State of Washington
DEPARTMENT OF FISH AND WILDLIFE
South Central Region • Region 3 • 1701 South 24th Avenue, Yakima, WA 98902-5720
Telephone: (509) 575-2740 • Fax: (509) 575-2474

April 30, 2019

SUBJECT: WDFW COMMENTS ON SE-19-00007 WEIHL ROAD IMPROVEMENT PROJECT

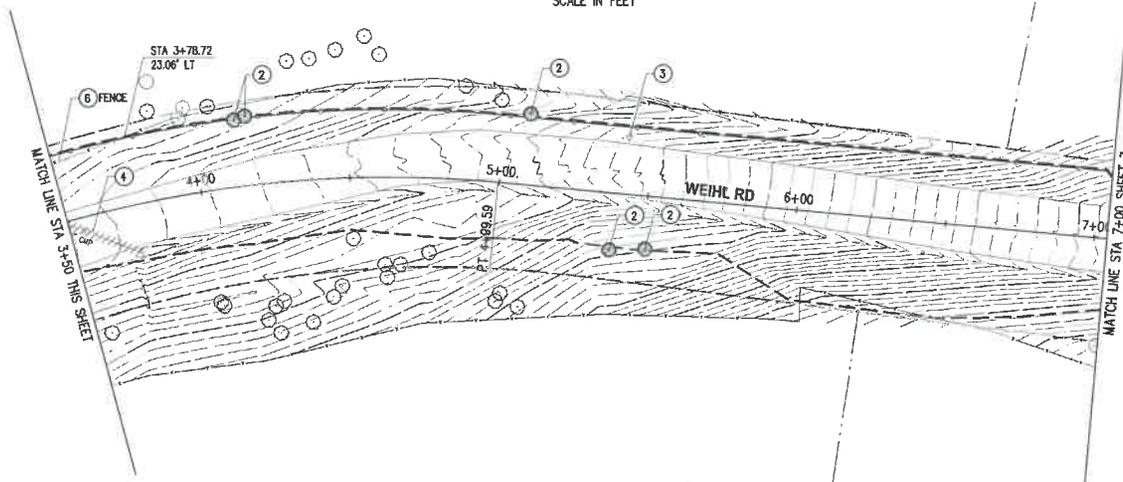
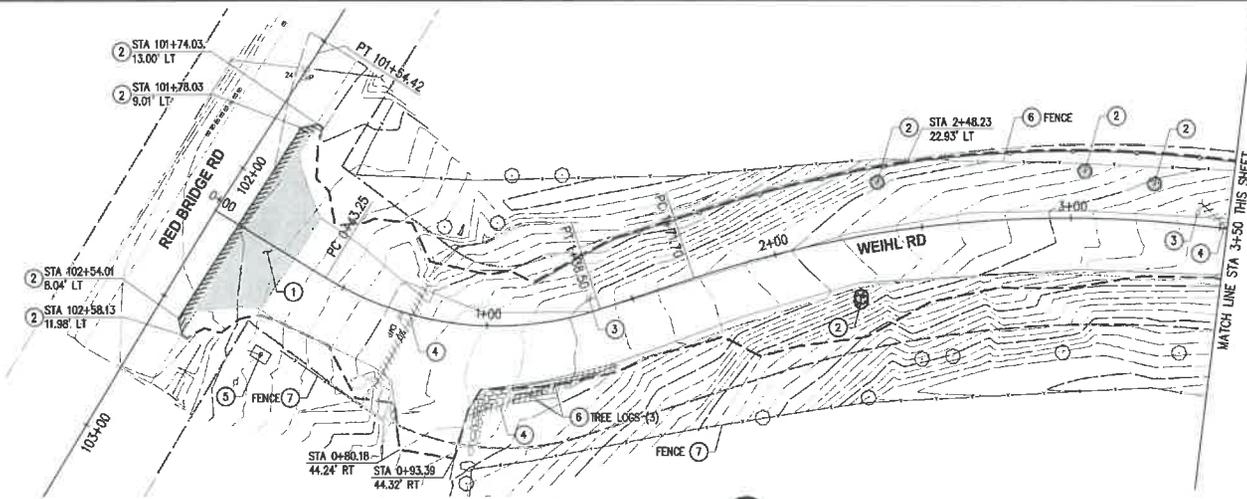
1. The attachment "PW Culvert Clarification Email, Taylor Gustafson" states that only one culvert will be replaced in this project. However, a review of the 90% submittal plan set indicates otherwise. On sheet 6, three culverts are slated for removal; on sheet 8, nine culverts are indicated for installation. Please clarify.

**CULVERT THRU WALL FACE DETAIL**  
NTS

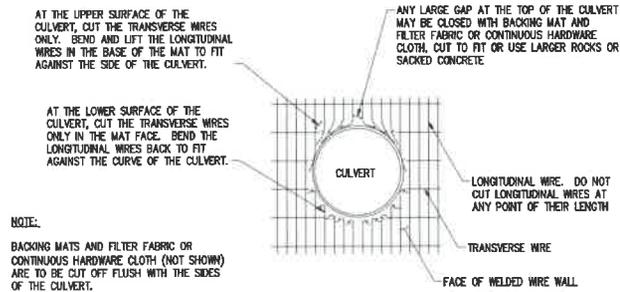
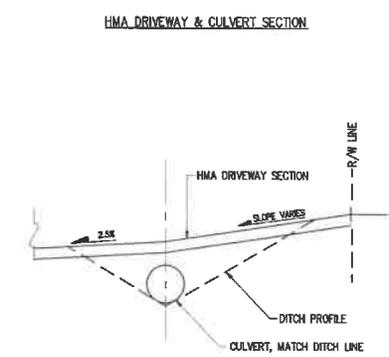
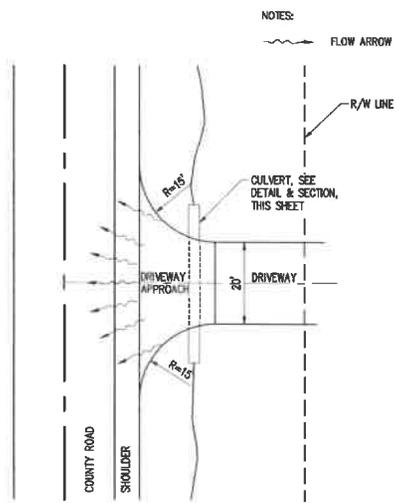
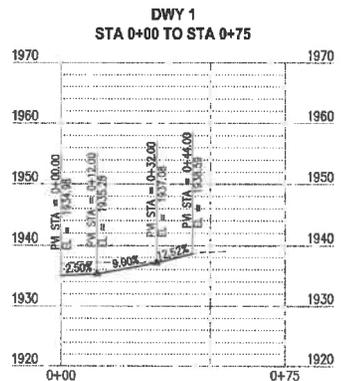
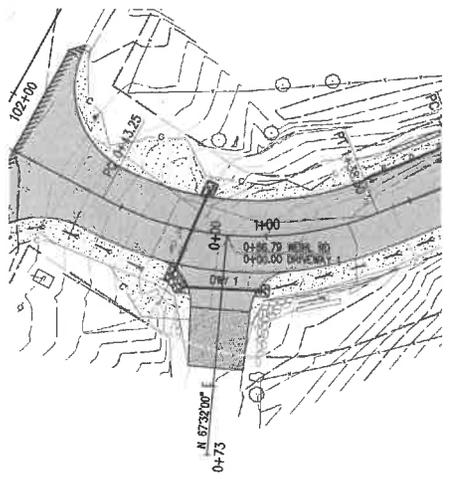
3. We recommend that you utilize biotechnical soil stabilization techniques at the base of the east-west culverts where they emerge from the welded wire wall. The flow which will empty from these culverts has the potential to erode the ground at the base of the proposed wall. On sheet 5,

under “Culvert Detail”, quarry spalls are shown for placement beneath the installed culverts. However, we recommend placing a geotextile fabric square, covered with rounded cobbles and planted with willow or dogwood stakes, beneath the outfall of the culverts (see Image 7). This technique has been used to great success in preventing erosion on slopes which are subject to overland, non-channelized flow.
